From: Elaine Walby on behalf of Planning.Responses
Sent: 07 May 2026 16:00
To: Planning Scanning
Subject: FW: Public comment on application A/44/26/PL
Attachments: Neutral review of Application 7.pdf

Technical and Procedural Review of Application A/44/26/PL

1. Executive Summary

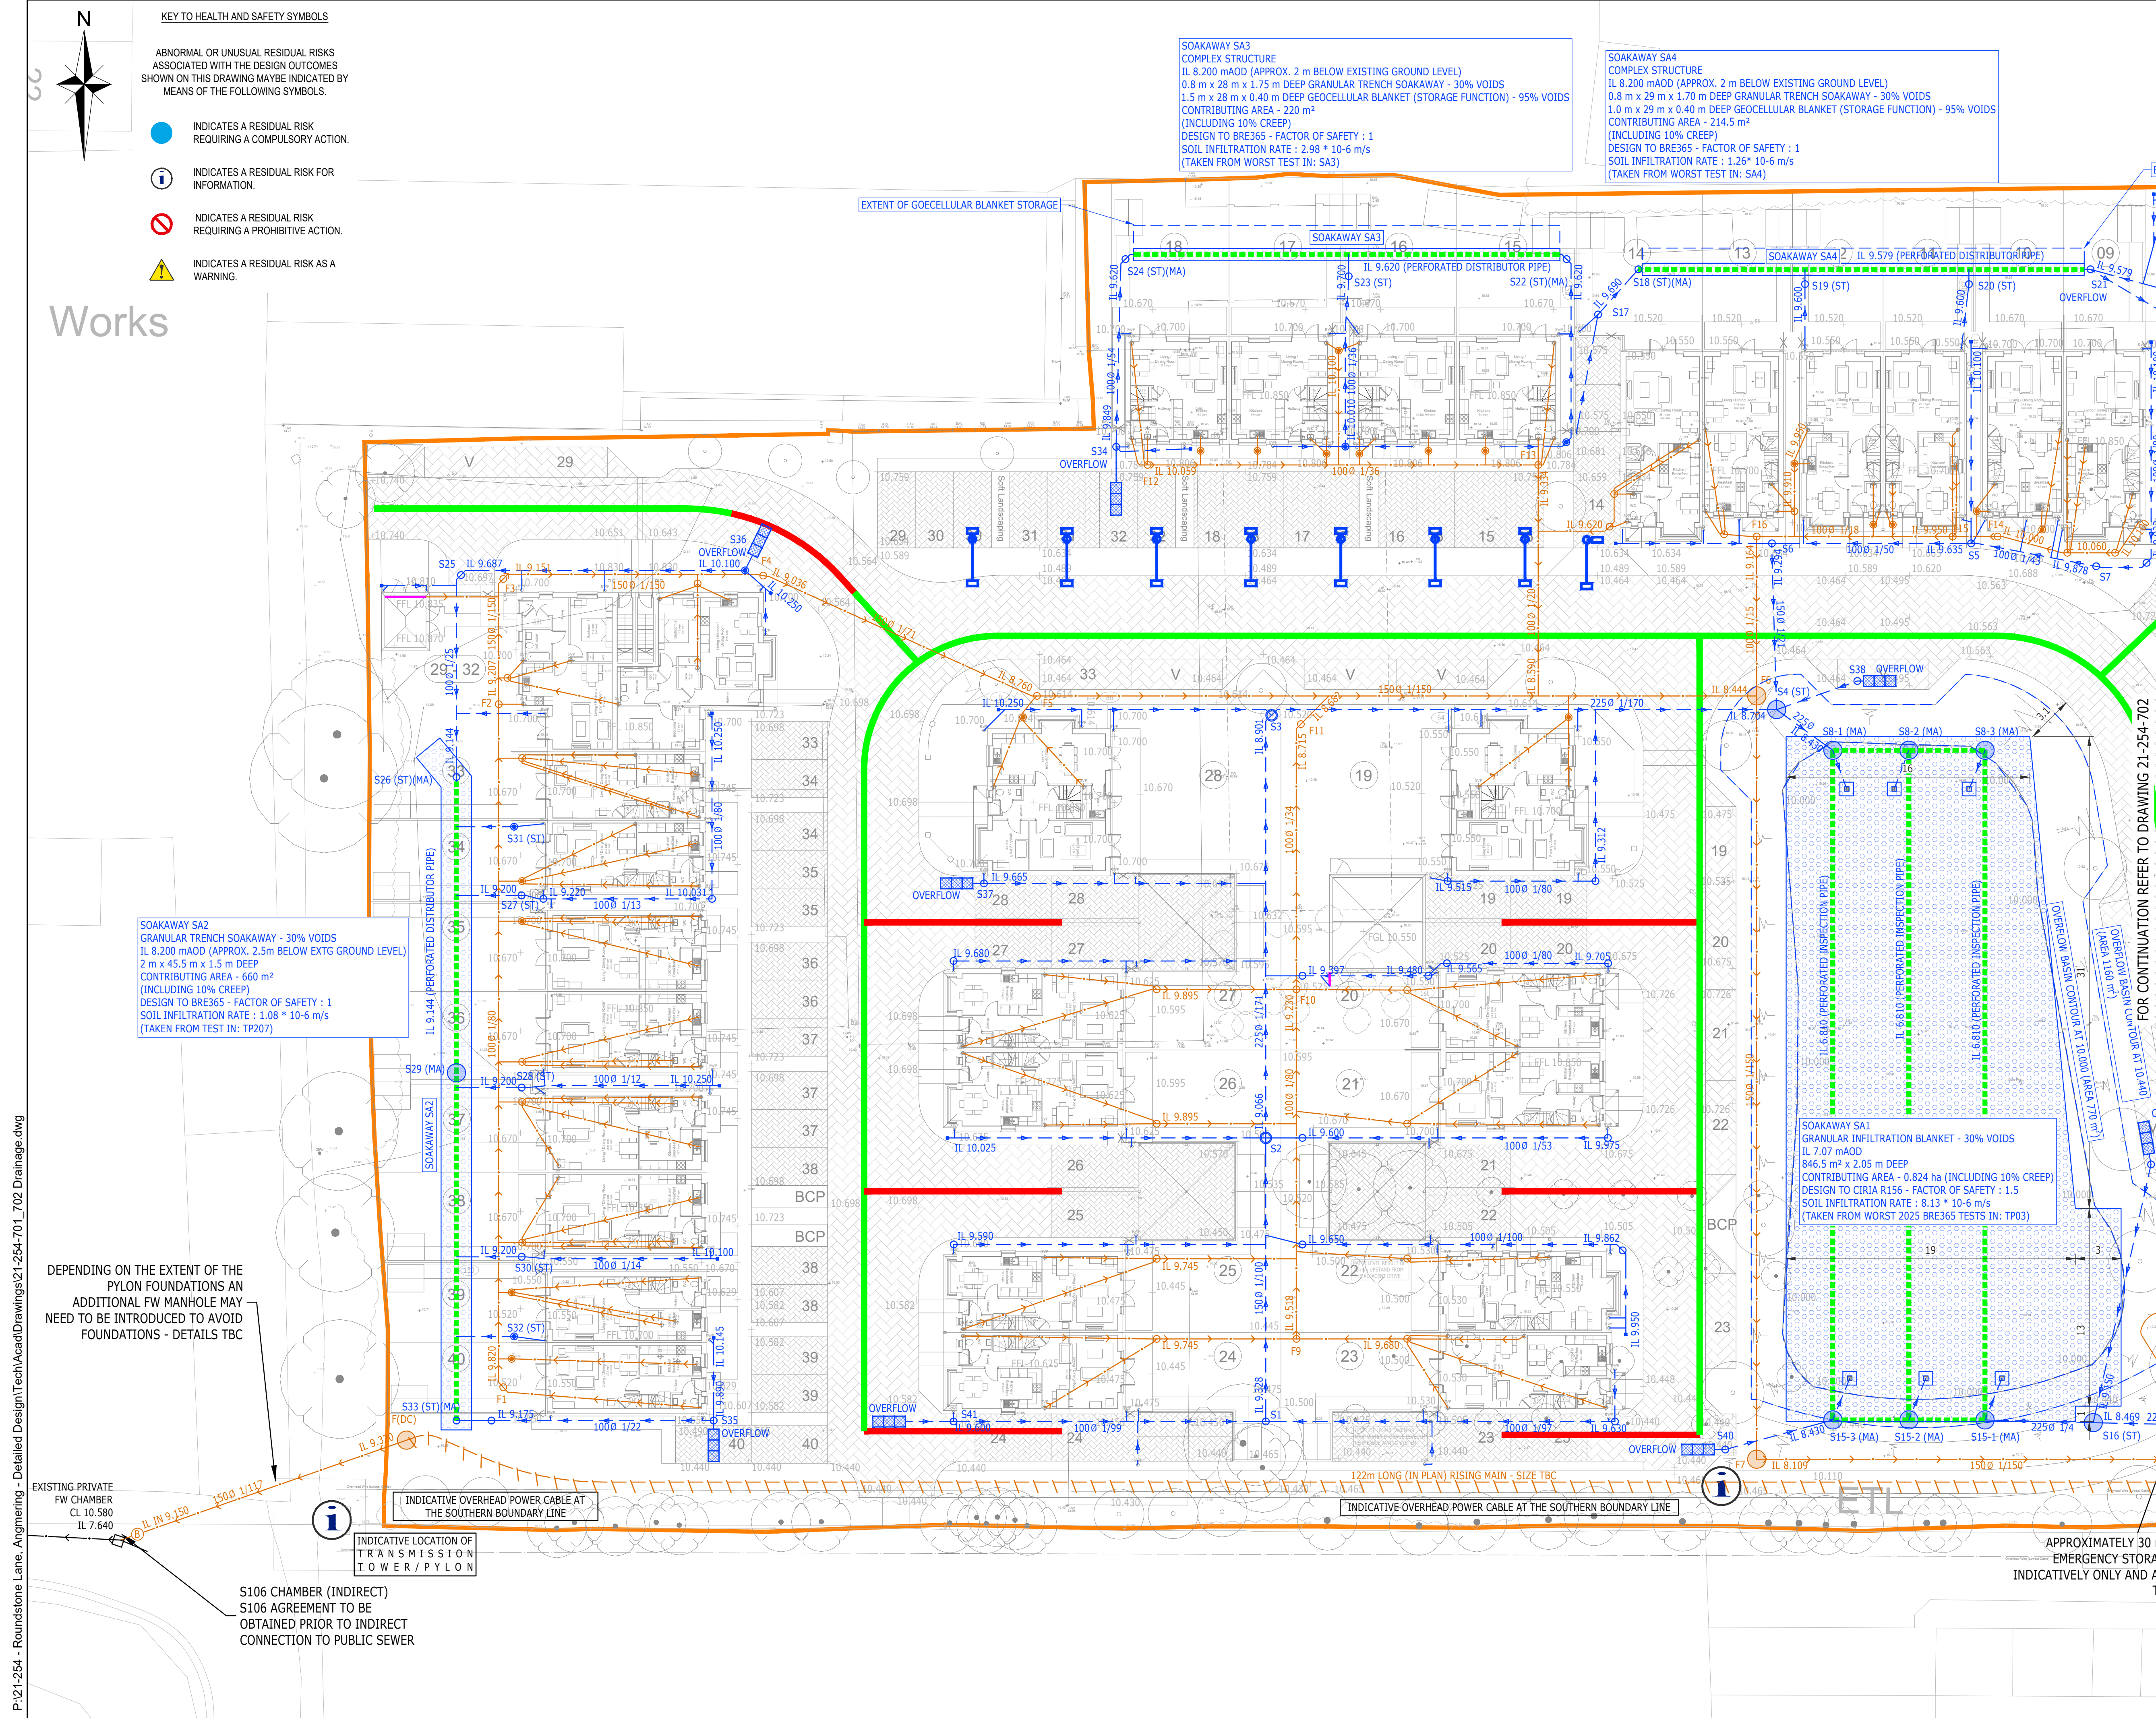
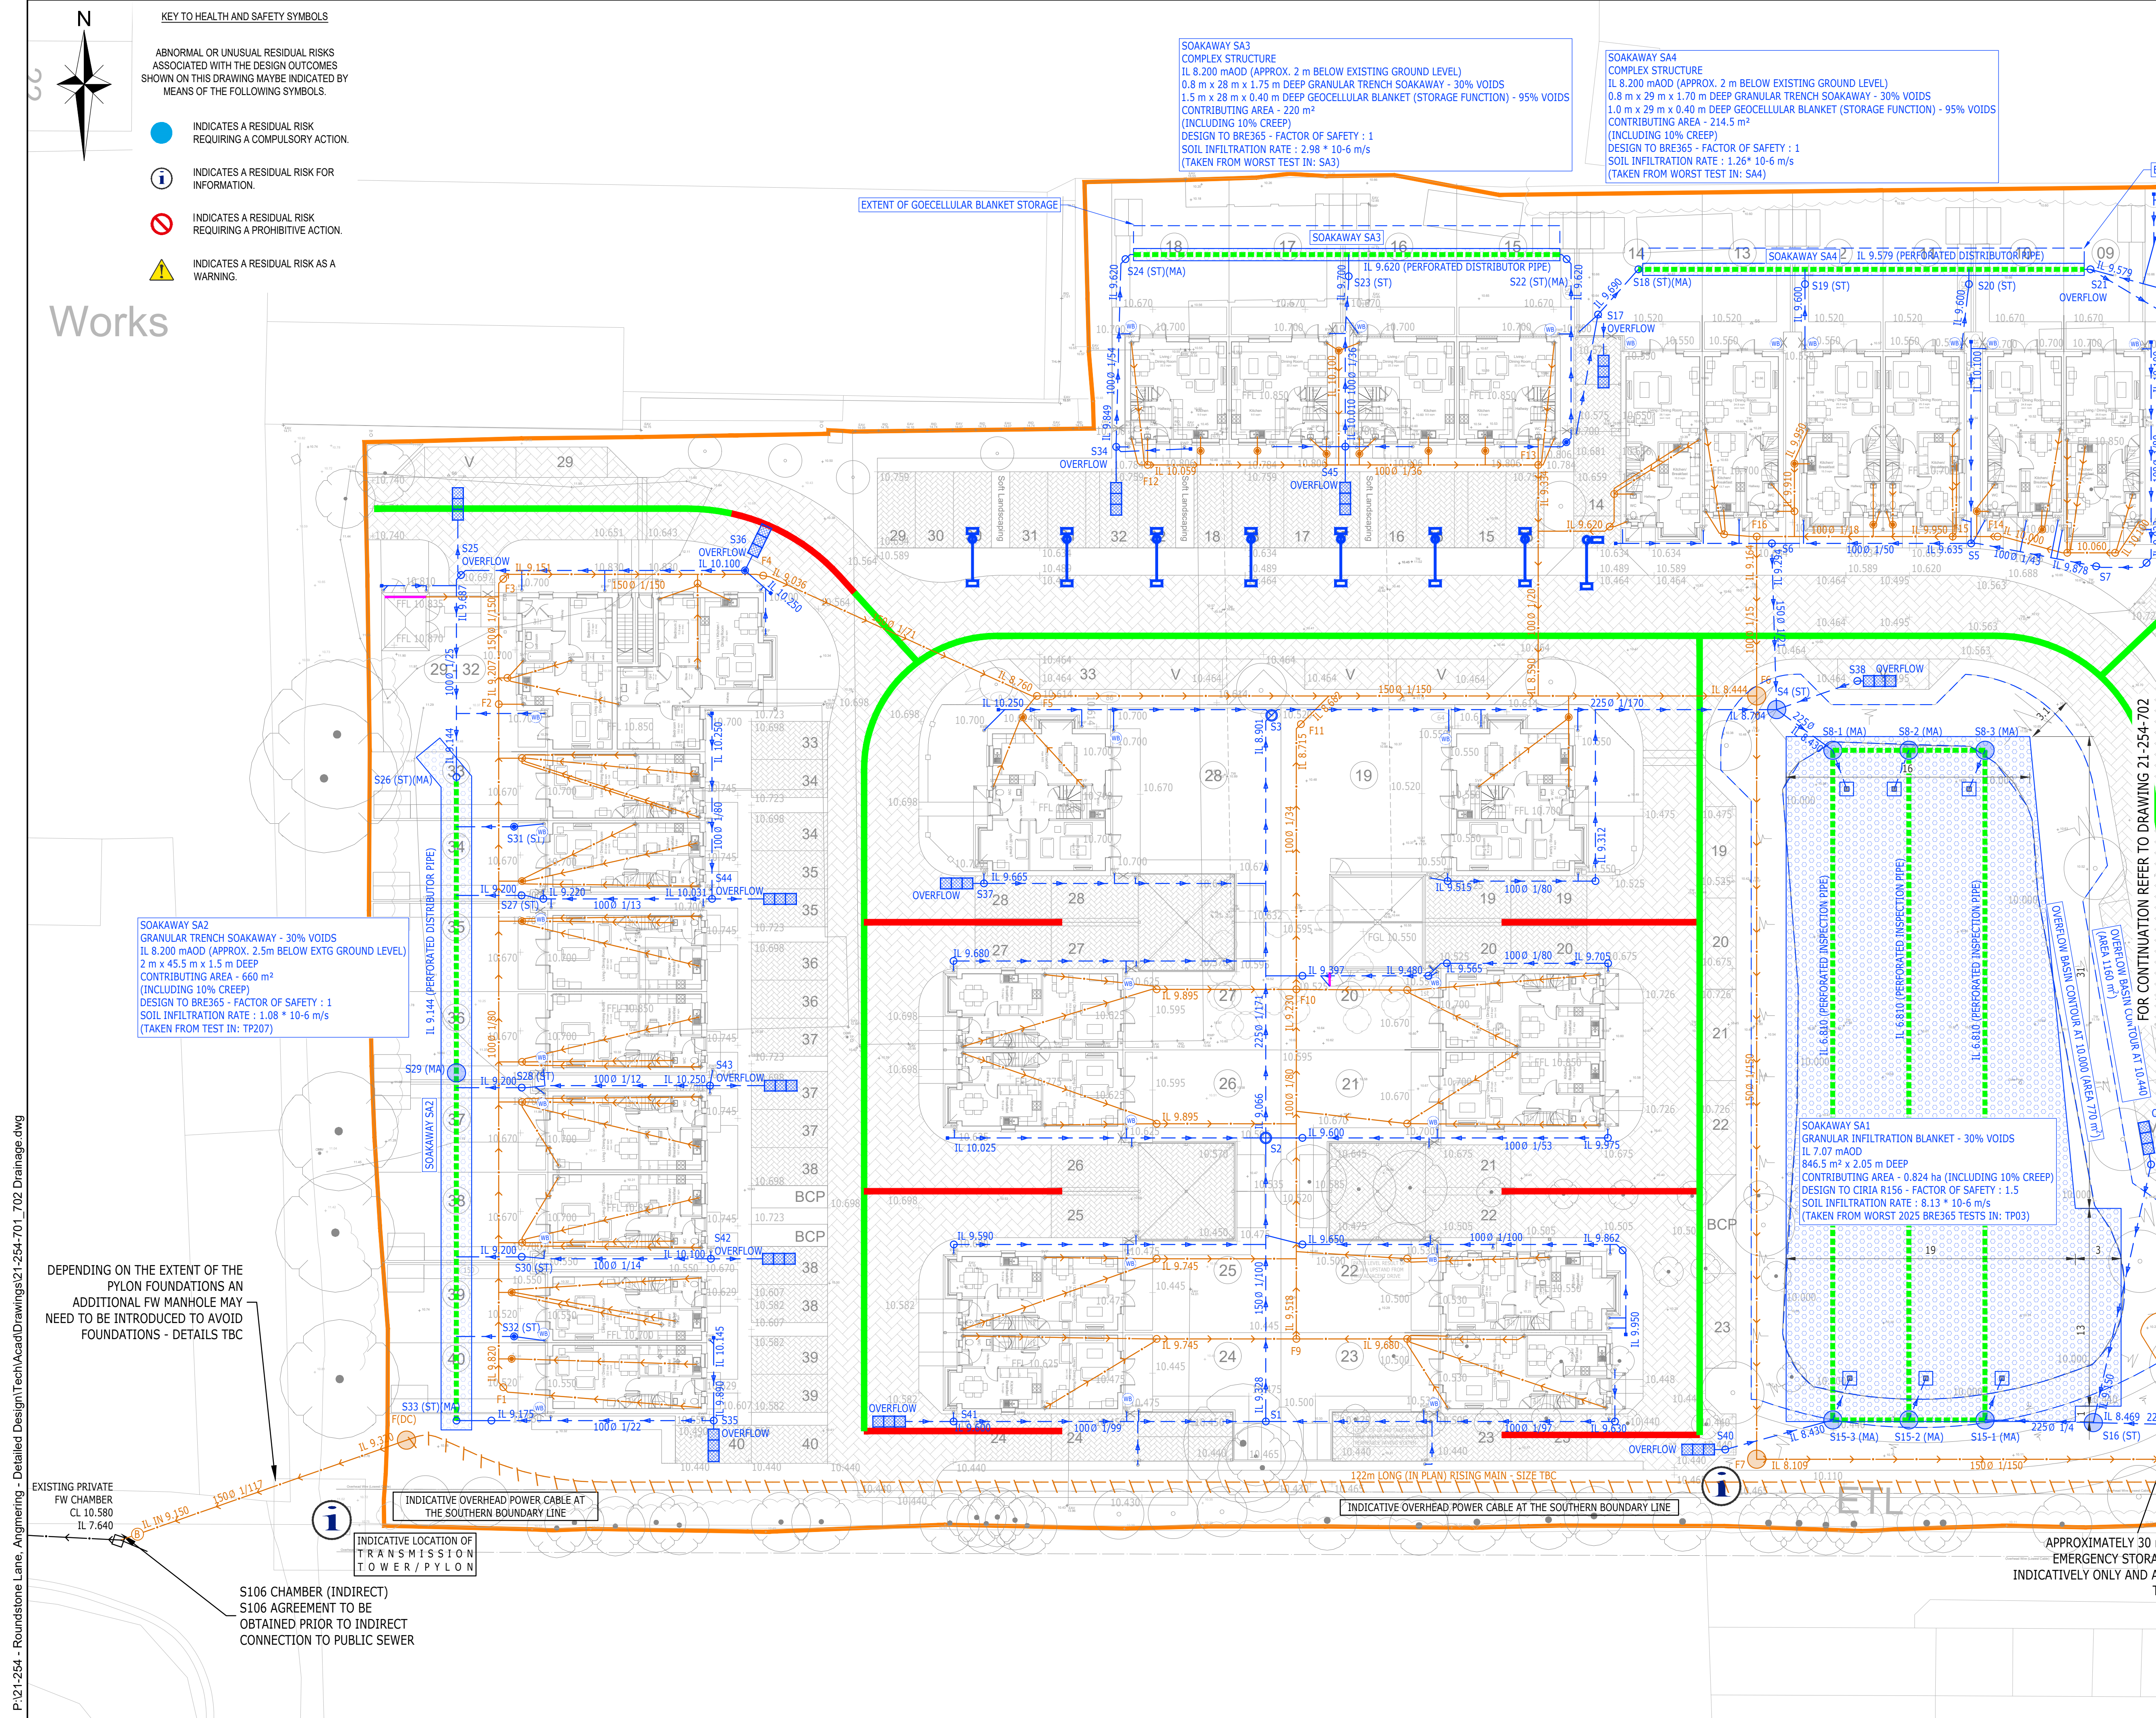
Features shown as present on the drainage drawings, including a rodding eye and inspection chamber with stated invert levels beside Plot 4, were not constructed on site. In addition, not all drainage construction drawings previously before the LPA appear to have been submitted with the present application.

Whilst it is noted in 2.7 that the surface water drainage management plan has been omitted from this submission, one assumes that any such plan would include the use of rodding eyes and inspection chambers such as these. This then raises the question as to how the plan can be coherent and executable if essential elements of the drainage system have not been constructed. The omission of these two particular features had already been brought to ADC's attention on 13 February 2026, almost a month before the date of this latest application.
